**Office of
Environment
& Heritage**

DOC18/679695

**Exhibition of Concord Repatriation General Hospital Redevelopment (Concept and Stage 1) -
1H Hospital Road, Concord West (SSD 9036)**

Attachment 1: OEH Comments - Exhibition of Concord Repatriation General Hospital Redevelopment (Concept and Stage 1) - 1H Hospital Road, Concord West (SSD 9036)

DRAWING NO.
IA064700-MSCP-AR-DRG-0101

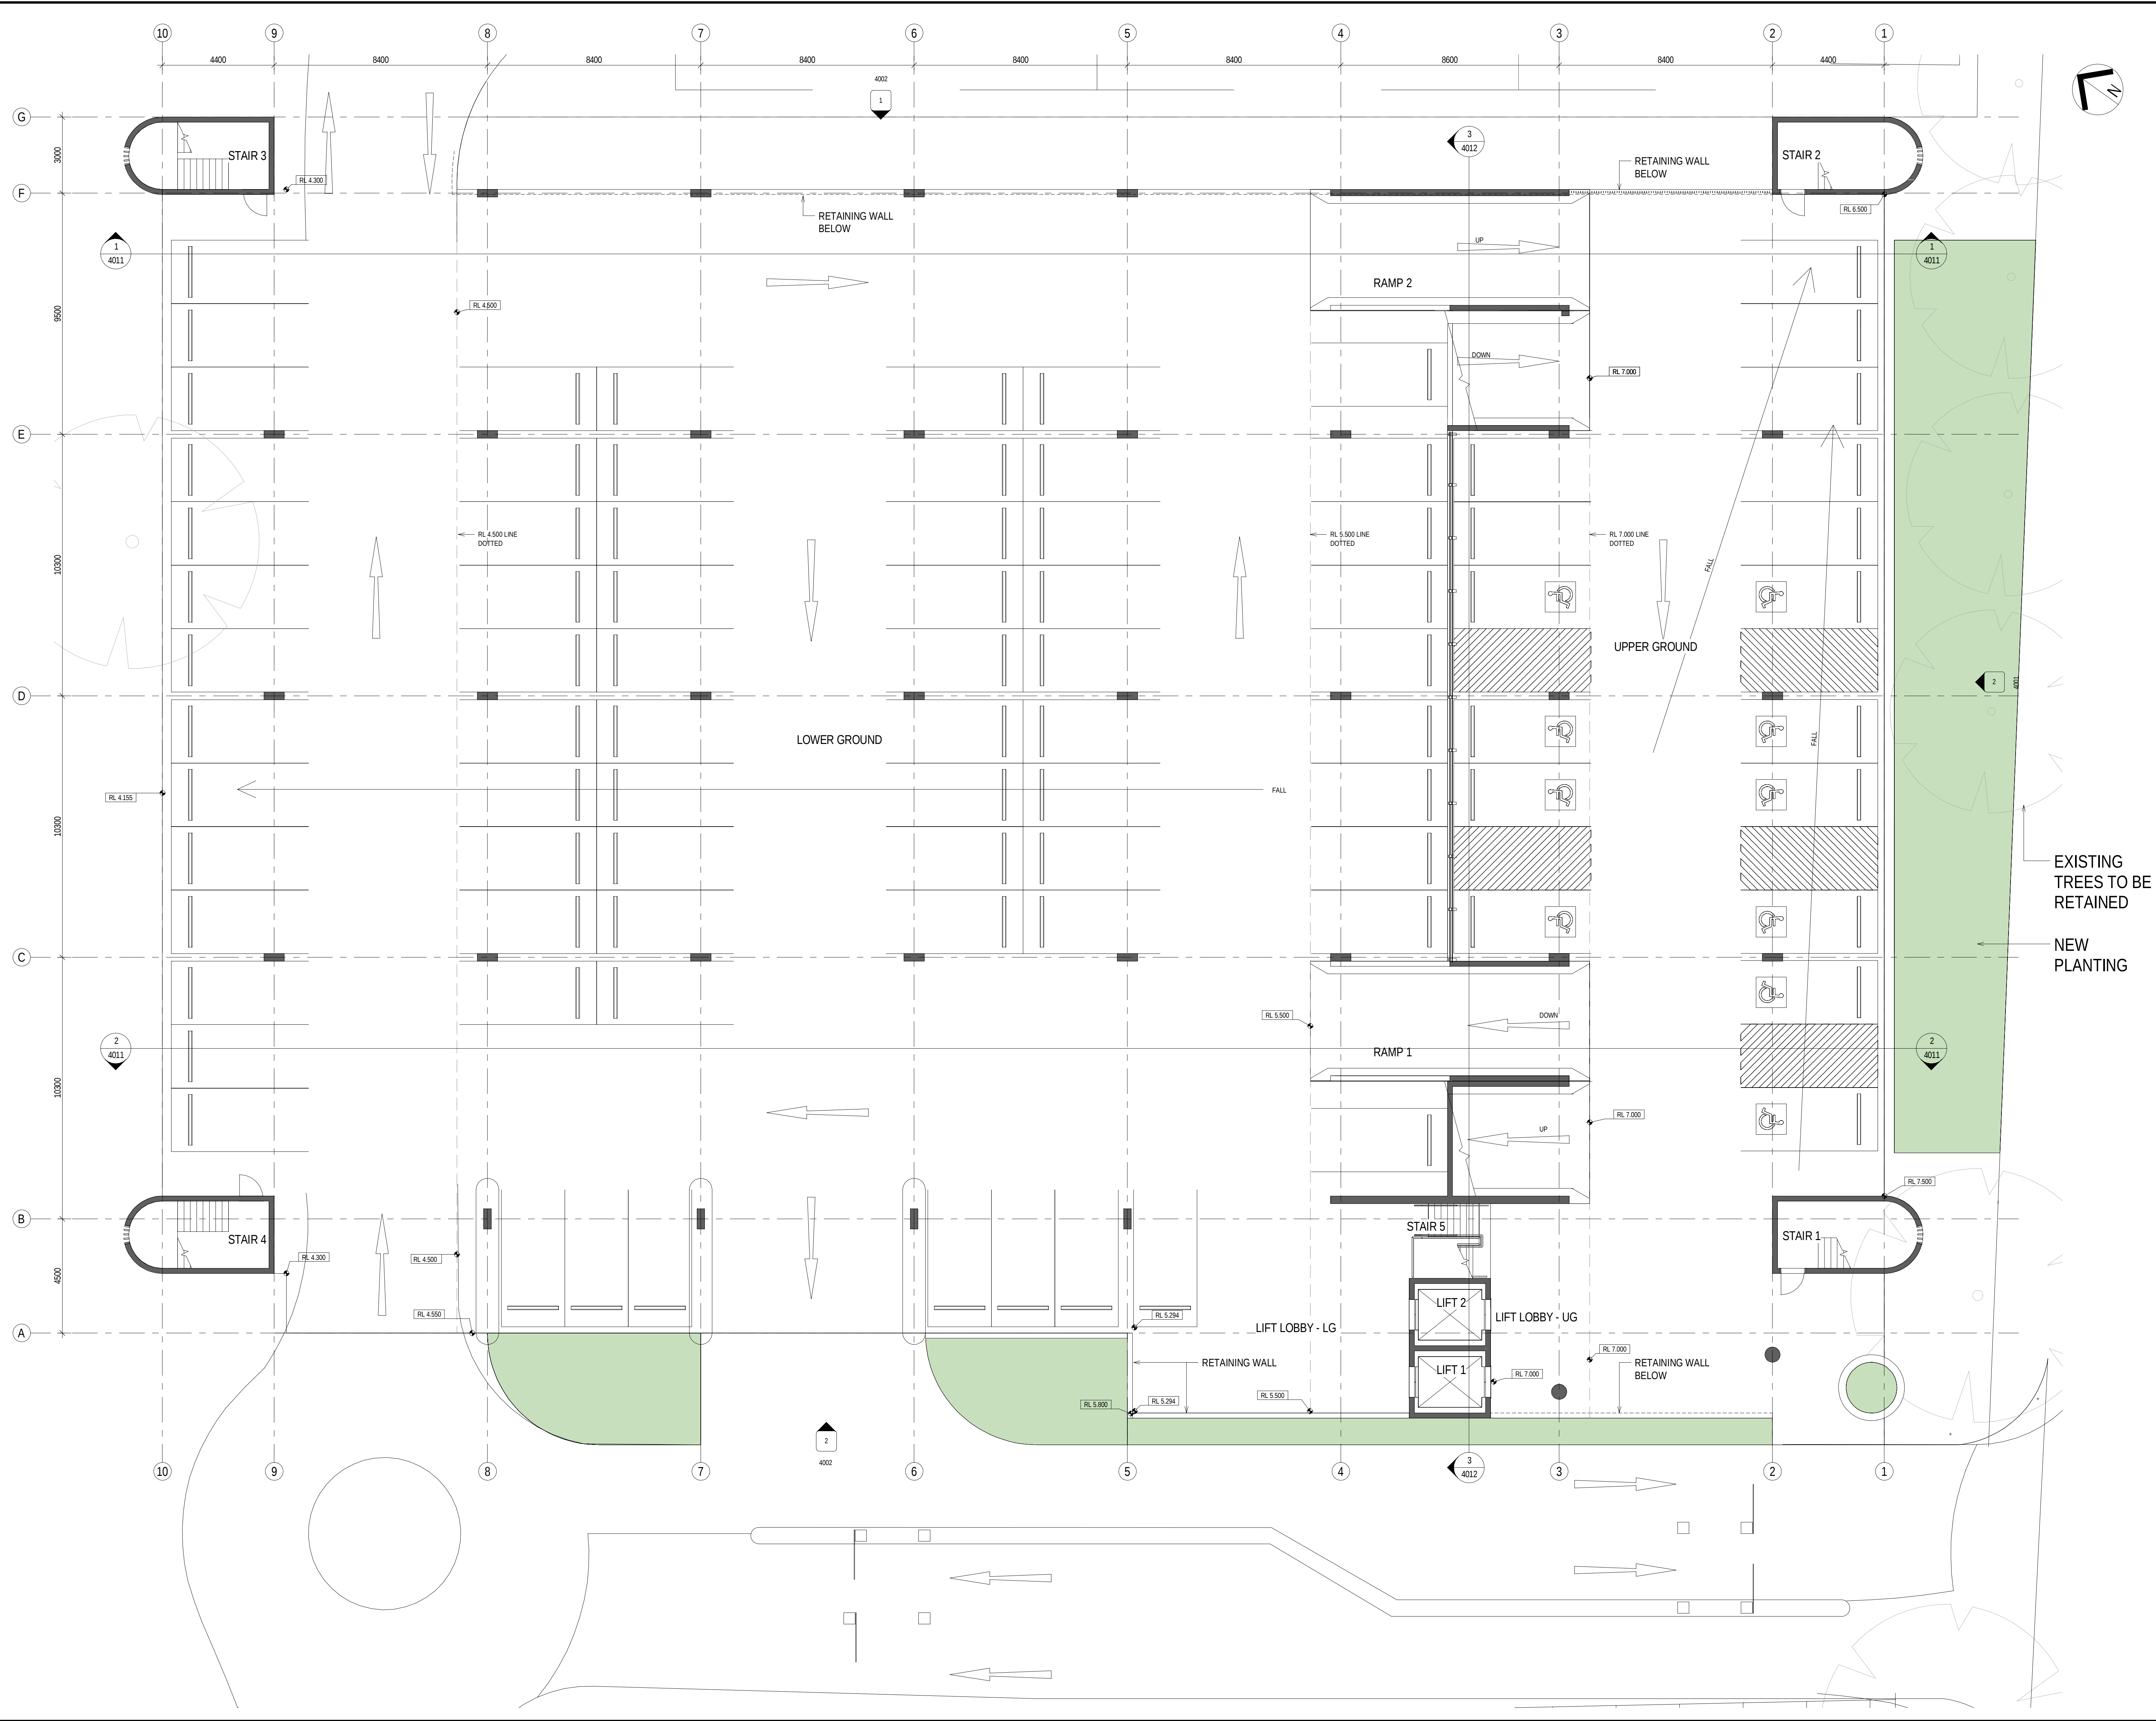
The site is located on the foreshore of the Parramatta River in proximity to both Brays Bay and Yaralla Bay and is surrounded by a sensitive estuarine environment. The proposal has not adequately demonstrated the protection of the following Endangered Ecological Communities (EECs) located adjacent to the proposed multi-storey five level car park (Stage 1) and the water quality of Parramatta River.

OEH notes that part of the site is zoned E2 Environmental Conservation in the location where the multi-storey car park is proposed to be located. It is unclear whether the proposed multi storey car park is permissible in this location given the part E2 Zoning, as it is not a prescribed zone under the Infrastructure SEPP (Clauses 56 and 57) and the design of the proposed multi-storey car park does not currently appear to be consistent with the E2 zone objectives.

OEH has reviewed the Soil and Water report prepared by Taylor Thomson Whitting. It states the proposed stormwater systems do not discharge to Council's stormwater system, but directly to Parramatta River / Sydney Harbour. A combination of a GPT plus a Stormwater360 Jellyfish JF3250-24-4 can meet the (pollution) reduction targets for the main works on the southern side of hospital road. It also states that 'the proposed multi-deck car park on the north side of Hospital Road can similarly meet stormwater quality targets through the use of a proprietary stormwater treatment device'. There is no detail of what this device is and how runoff from the development to the north of Hospital Road is to be treated. This is inconsistent with the SEARs. Further, this report states the preliminary site contamination investigation completed by Douglas Partners in June 2016, notes potential sources and types of contaminants at the proposed development site in section 3.2 of the Soil and Water report including at the 'main hospital car park with potential for leakage of engine oil and or petrol penetrating into the ground' with contaminant types being heavy metals, TRH and BTEX.

An updated Soil and Water Report is required that includes stormwater treatment devices to manage runoff and treat and remove contaminants and pollutants generated from the development to mitigate impacts on the sensitive vegetation communities. A Water Quality management plan is required, and the proposal should make use of stormwater quality improvement devices. OEH is concerned with heavy metals and hydrocarbons, oils and runoff flowing directly into river and harbour which is inconsistent with the policies outlined below.

Further, the proposed multi-storey car park is in a high-risk acid sulfate soils area. Any forthcoming consent should condition the need to prepare an acid sulfate soils management plan, if for the multi-storey car park, excavation exceeds disturbance of 1000 tonnes of soil and pile diameters exceed 0.6m to 0.9 m diameter on an 8m by 8m grid; and significant excavation is required into alluvial clays (or excavation into clays below RL 5m) for earthworks (as noted in the Soil and Water Report). It is noted that the hospital building basement excavation exceeds 2400 tonnes as such a management plan should be prepared.
